This plan is approved only if constructed with the notes shown regarding building code compliance.

APPROVED
 Limited building only review
 General builder responsible for
 full compliance with the code

05/01/2020

12 x 24 Traditional Victorian Shed Plans

1 POURED CONCRETE PIER FOUNDATION
 $\frac{3}{4}$ " = 1'-0" SIDE VIEW

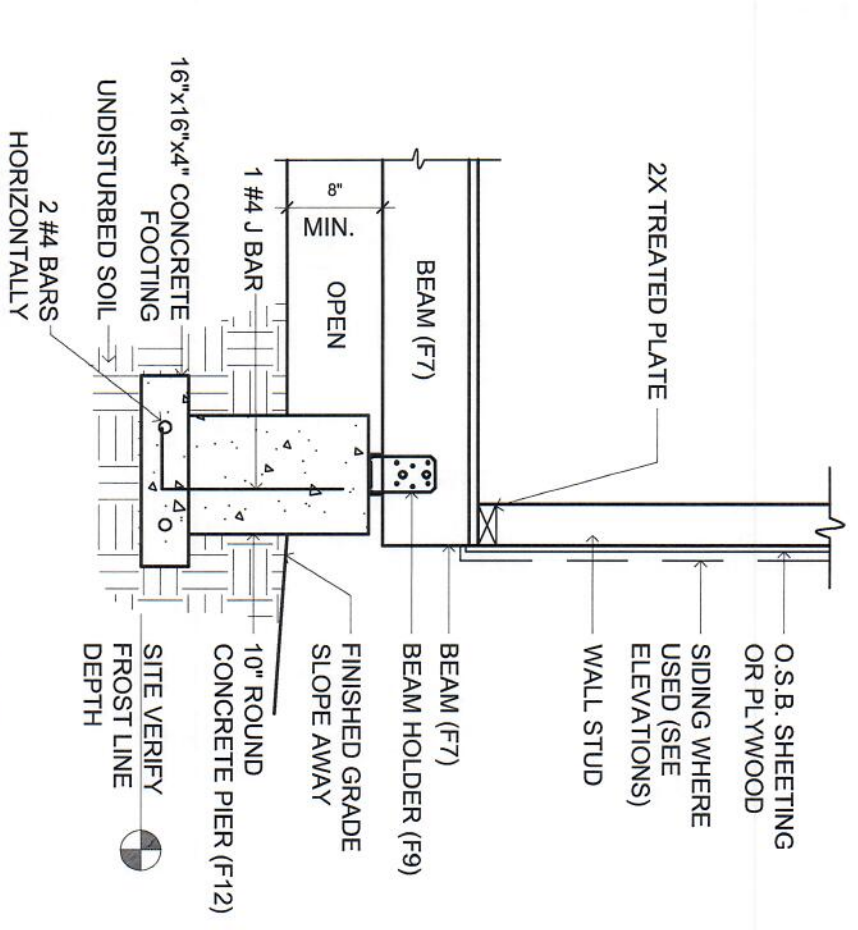
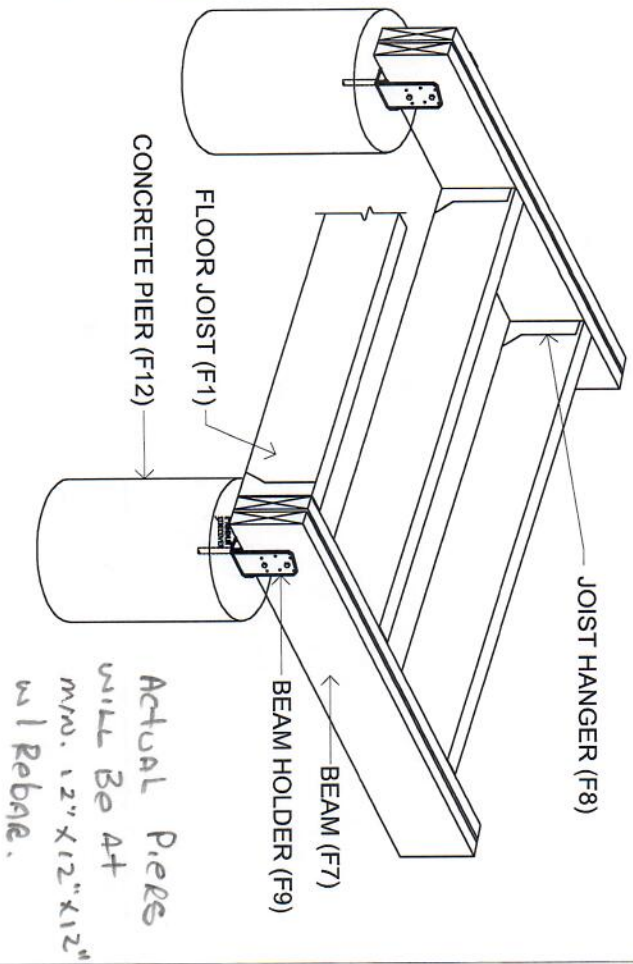
Must be min 16x16x 6 inches thick for min. Code.

ROOF FRAMING PLAN

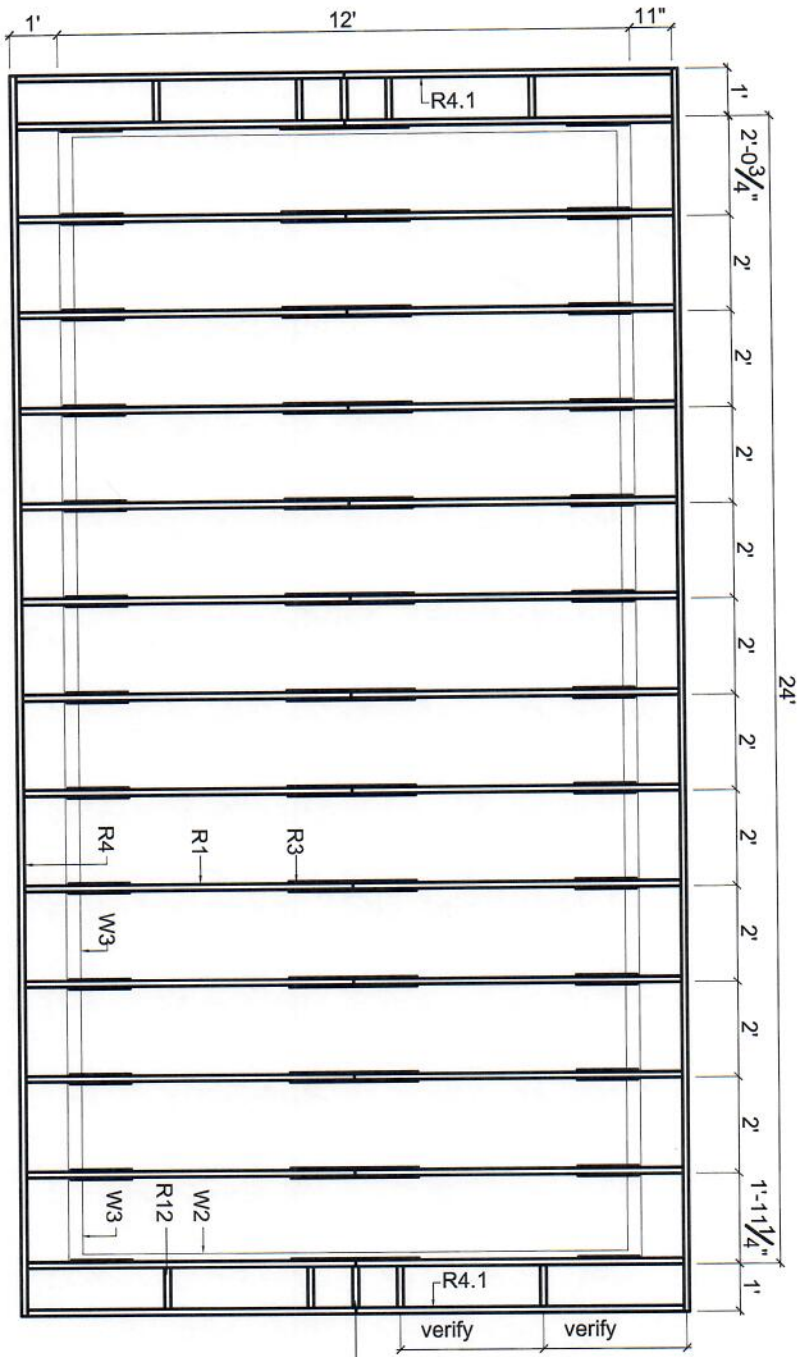
Ceiling joists must be minimum 2x6 for 16"oc or 2x8 for 24"oc. Roof may not be site built trusses without engineers design.

Roof must be framed according to the prescriptive method of the NC Residential Building Code 2018, or this page/design must be sealed by a NC Structural Engineer

RAFTER DETAIL - 10 / 12 PITCH

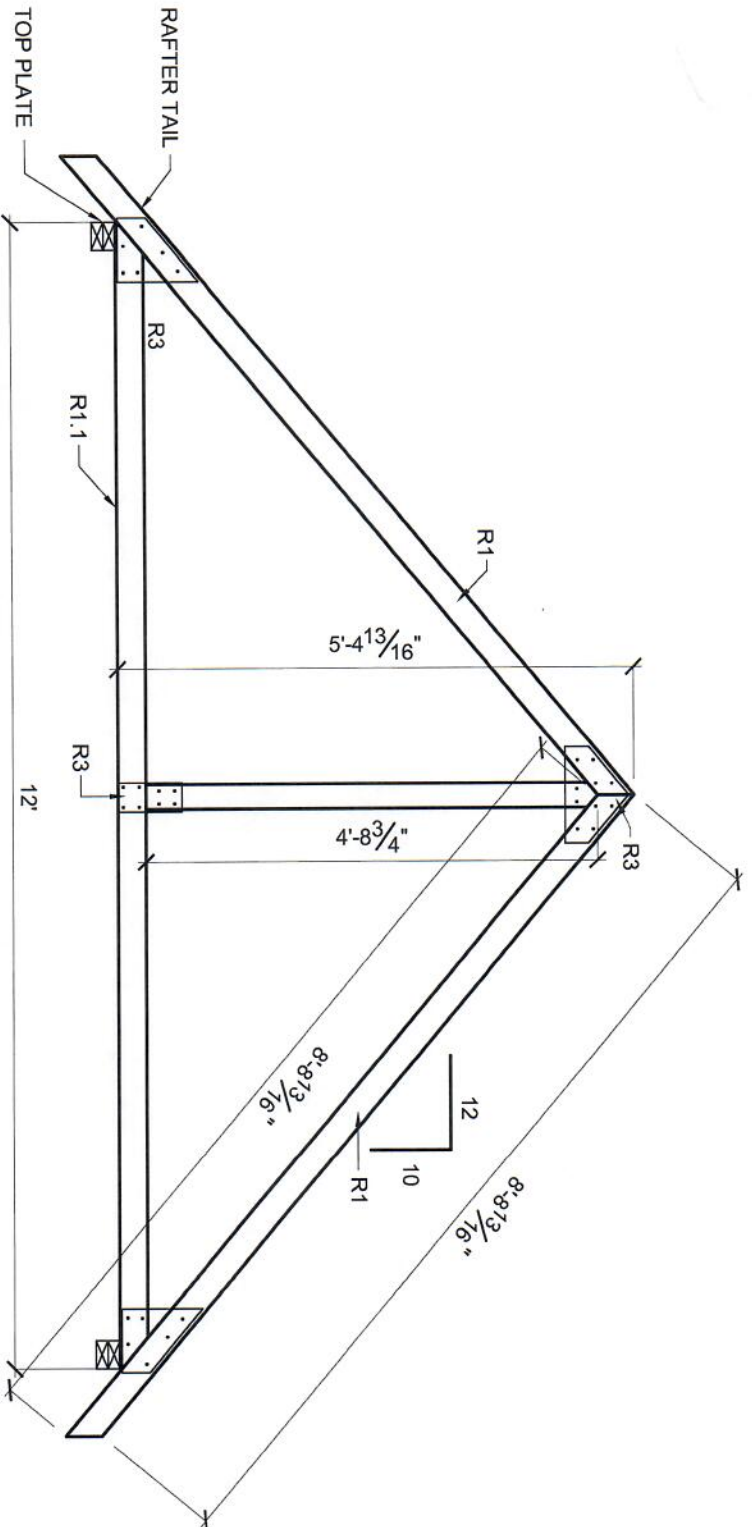
Minimum Code Req.
